From: Chris Moore [REDACTED]
Sent: 05 August 2019 11:31
To: Nicola Moore
Subject: RE: F/17/19/HH - 40 Johnson Way
Attachments: Ex Elevations.pdf; Prop Elevations.pdf

From: Nicola Moore [REDACTED]
Sent: 05 August 2019 11:16
To: Chris Moore [REDACTED]
Subject: F/17/19/HH - 40 Johnson Way

With reference to the above application, I have noticed that the existing and proposed side elevations have been incorrectly labelled as front elevation.

EXISTING ELEVATIONS

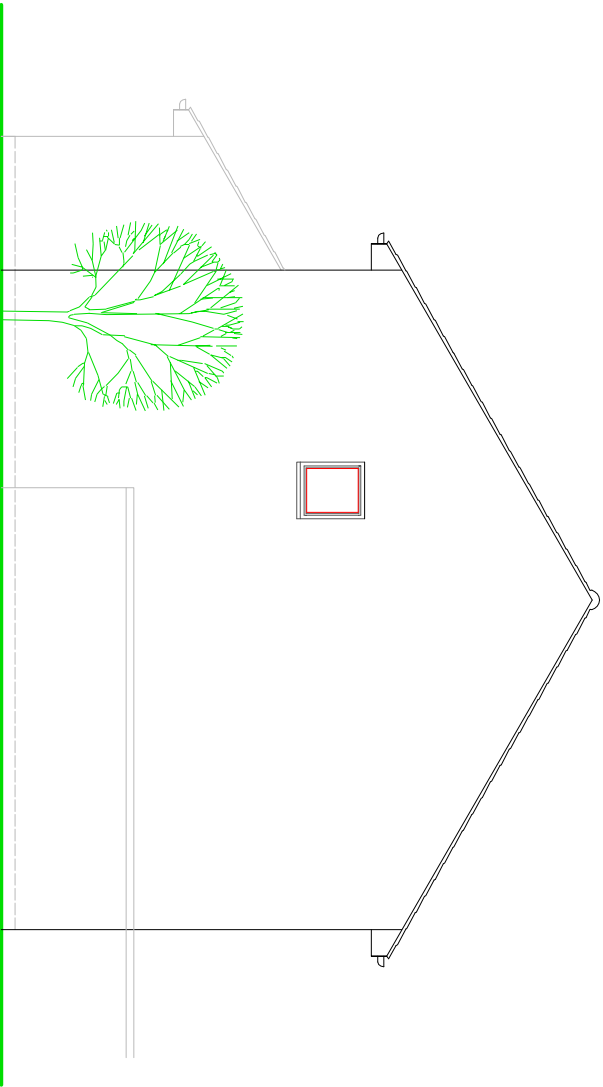
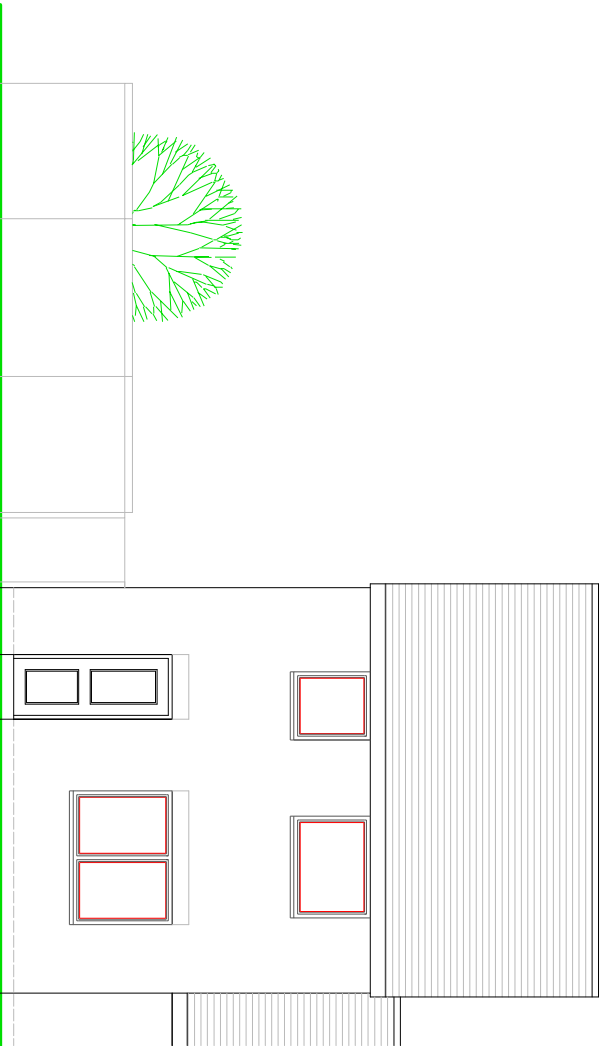
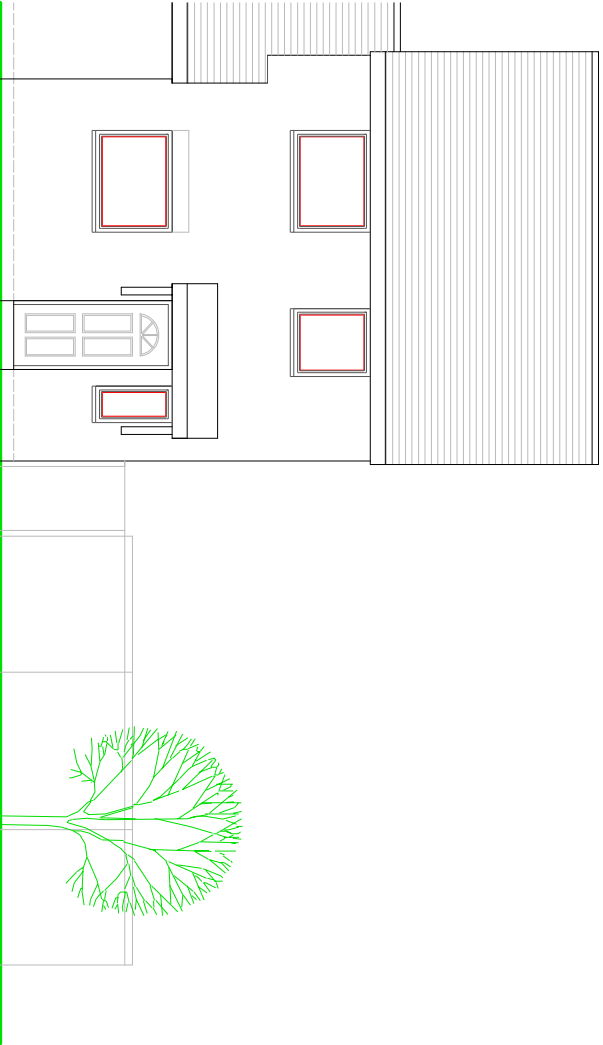
Please could you re submit amended plans or alternatively I can amend the plans if you are happy for me to do this.

Thanks for that – I attach revised elevations – please let me know if there is anything else you need.
